**Re: Starbuck's on Wyoming
4601 Wyoming Blvd. NE
Request Temporary C.O. - Accepted (F19D013C)
Engineer Stamp Dated 8/18/17**

Based on the Certification received 8/30/2017, the site is acceptable for a 60-day Temporary Release of Certificate of Occupancy by Hydrology. However, before a permanent CO can be accepted the following comments must be addressed:

SHEET NUMBER:
C-0010

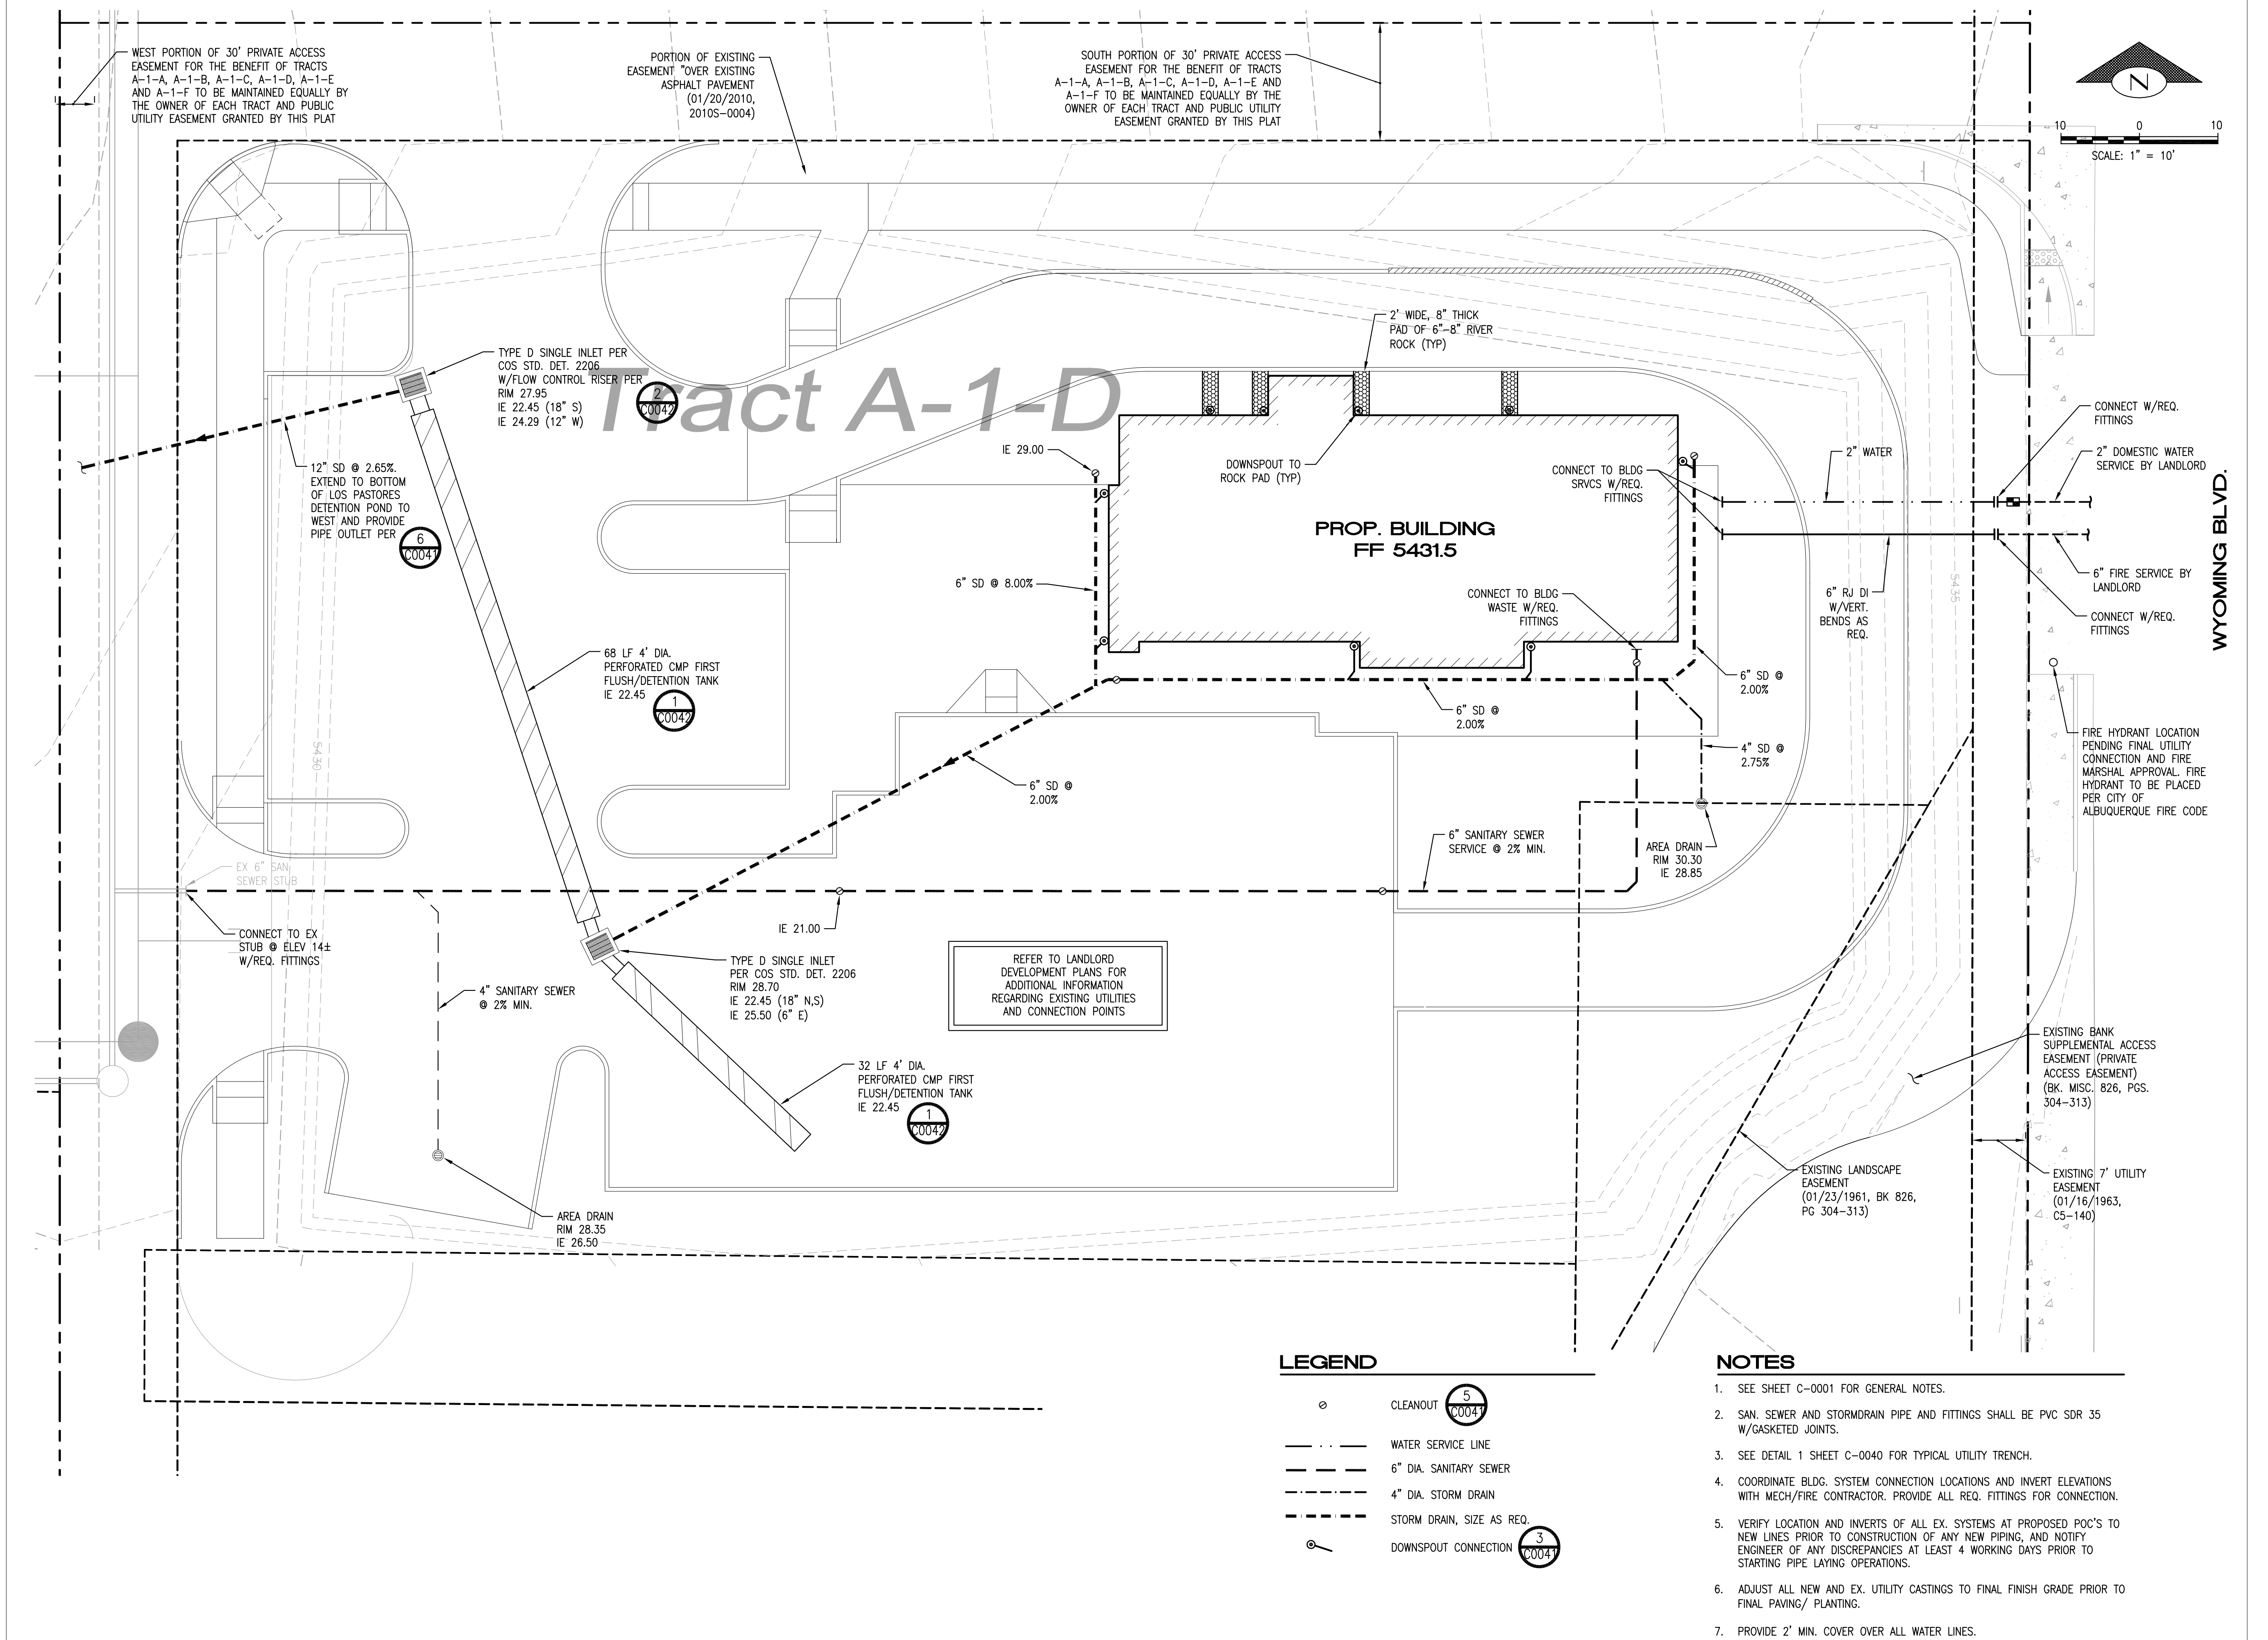
- Dumpster area must drain to sanitary inlet
- 12" storm pipe must be completed to pond
